**Re: Loves – Sunport at 3200 Broadway Blvd SE
Erosion and Sediment Control Plan
Engineer's Stamp Date 7/1/24 (M14E038)**

Based on the information in your submittal, received on 9/10/24, the ESC Plan and NOI cannot be approved for Building Permit or Work Order until the following comments are addressed.

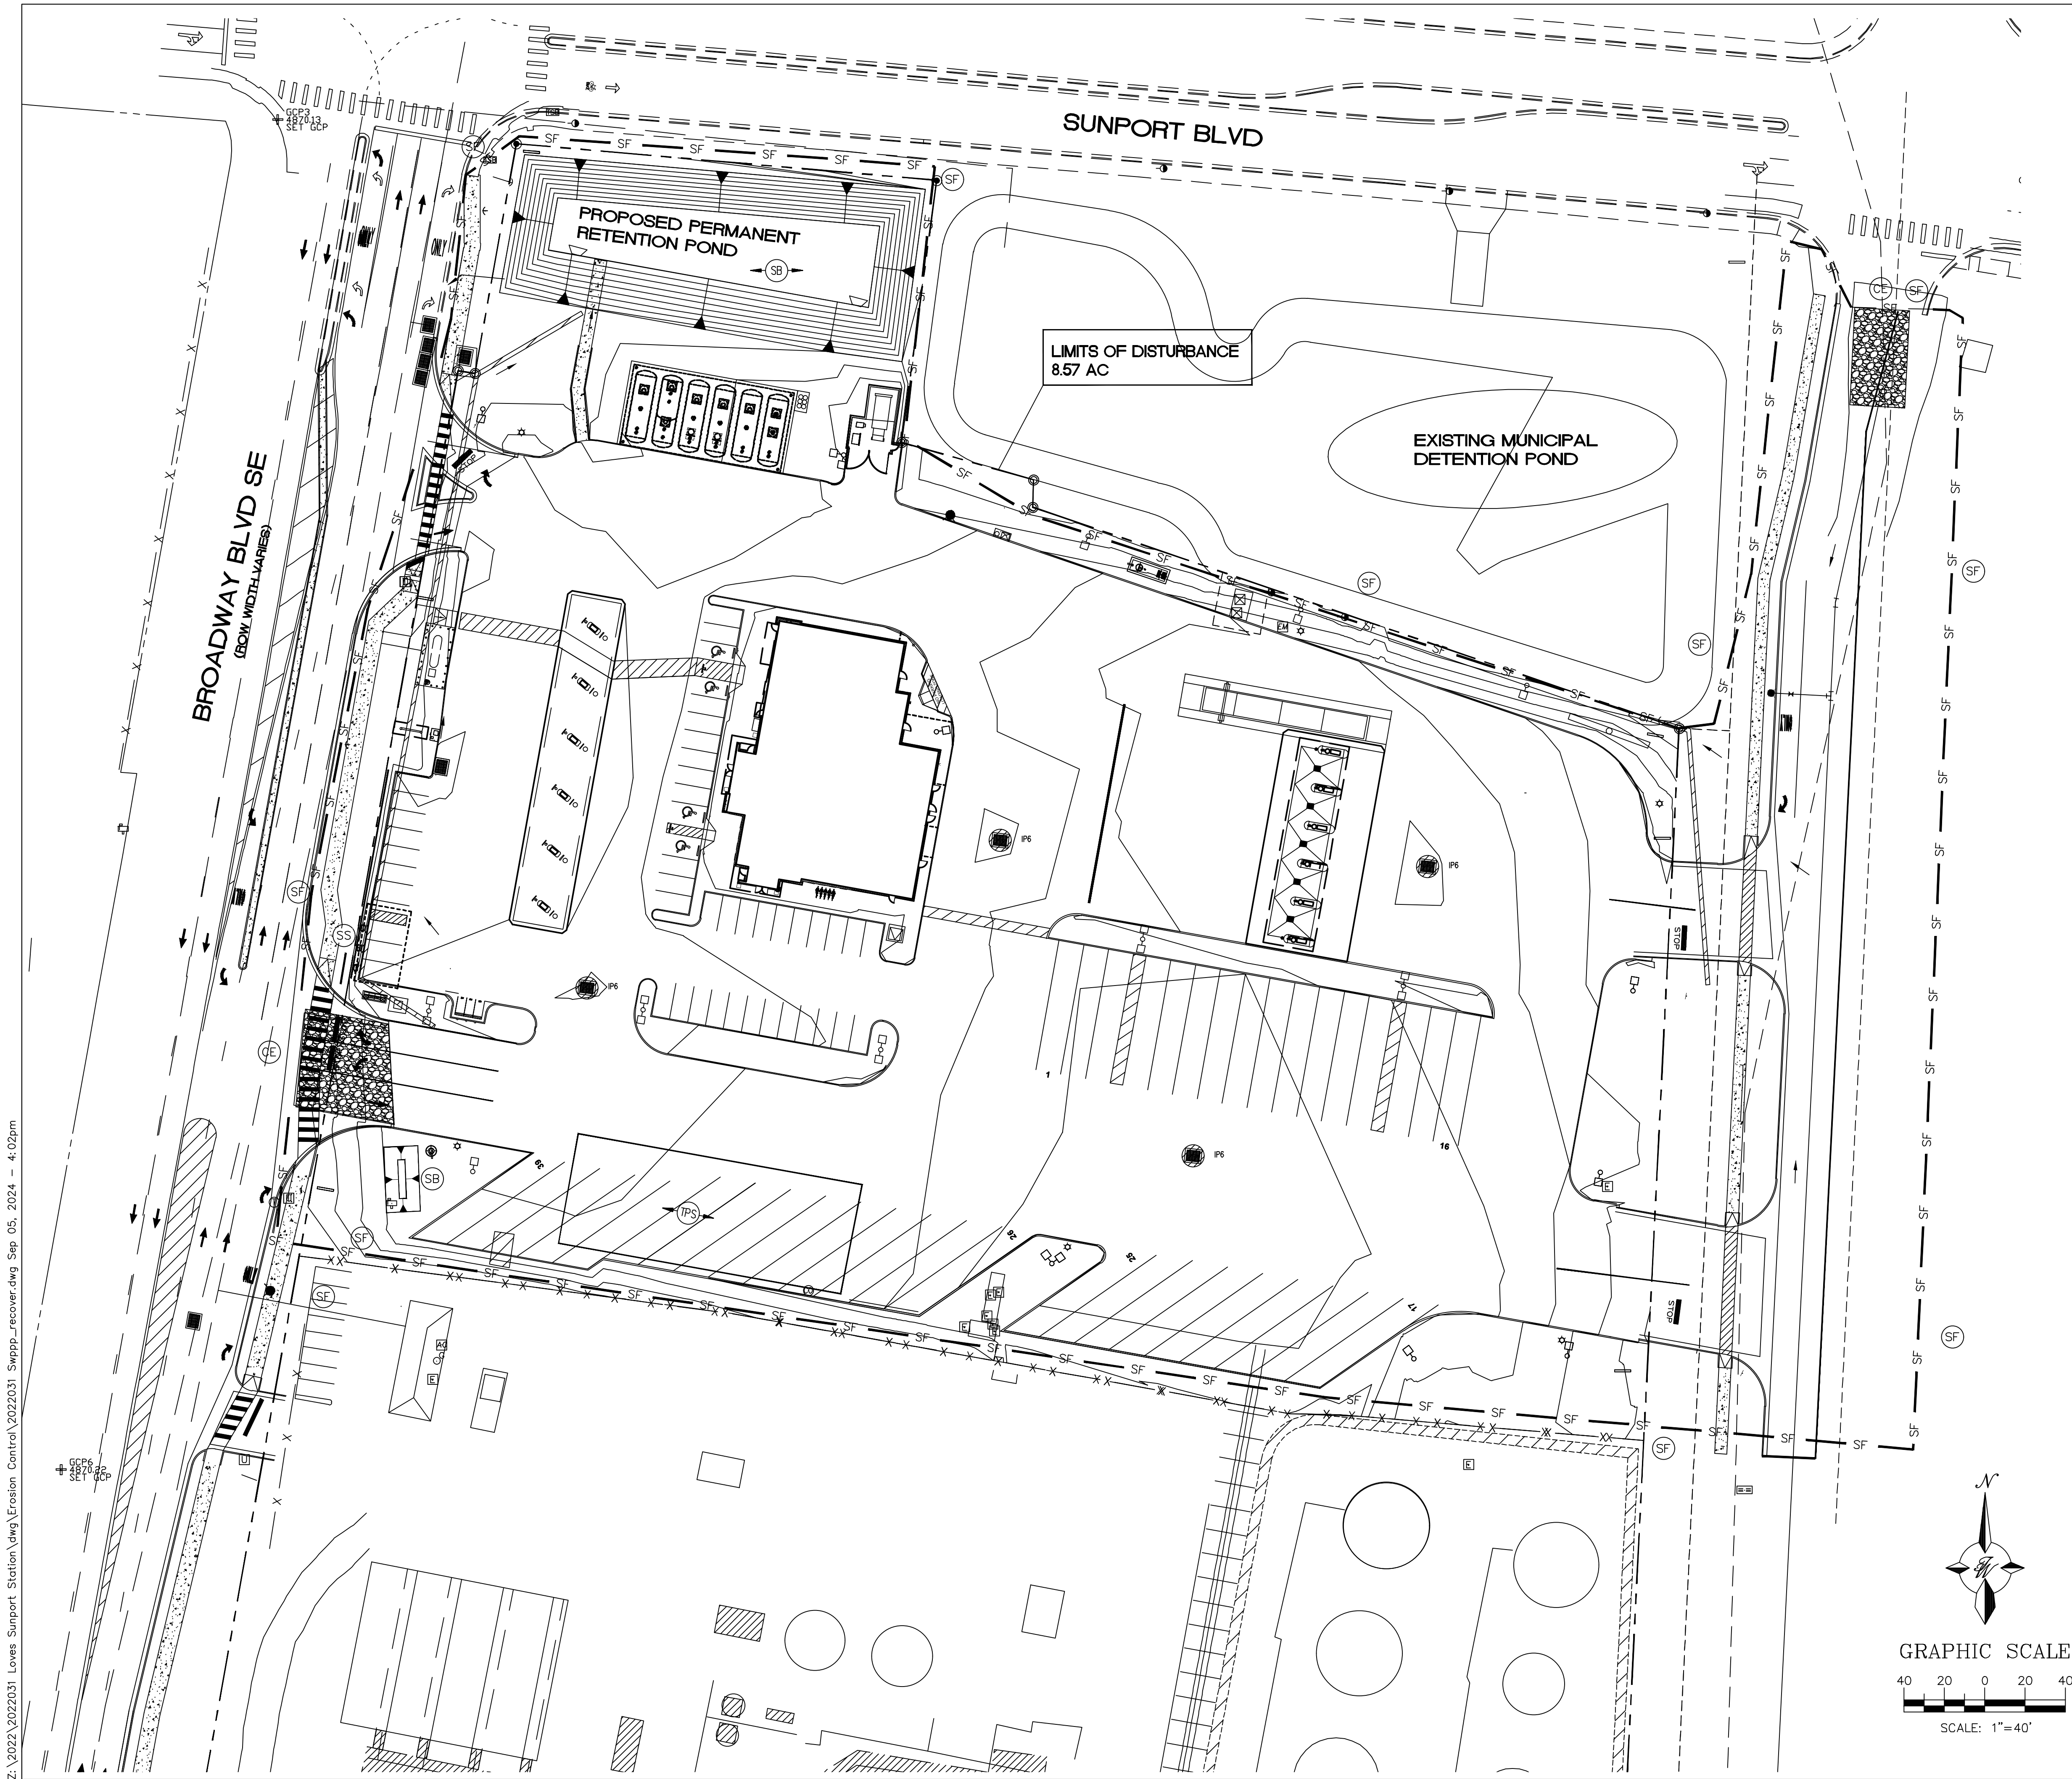
2. The existing grades are missing. The existing and proposed grades must be shown on the ESC Plan and agree with the Grading Plan approved by Hydrology per GP7.2.4.b.ii.

3. Add spot elevations to the temporary diversion berm along the west property line to ensure fall into the retention pond at the site's northwest corner. The berm may have to be more than 2' high in existing low spots.

4. Identify the required volume and specify both Sediment Trap (ST) dimensions. Some portions of the site may drain first to the south ST and then later to the north ST as grades change and storm sewer is added at different times during construction. They should both be sized for the largest area draining to them at any time during construction. Identify the portion of the pond that will be below grade and the embankment height and spillway width, if any. The spillway may not be needed if the required volume is below the lowest existing grade at the outlet. Identify the depth below the outlet where sediment removal is required.

5. Locate additional berms along the north and south boundary to ensure stormwater stays onsite and is diverted into the STs. Since existing grades are missing from the ESC Plan, it is difficult to tell where those berms may be needed.
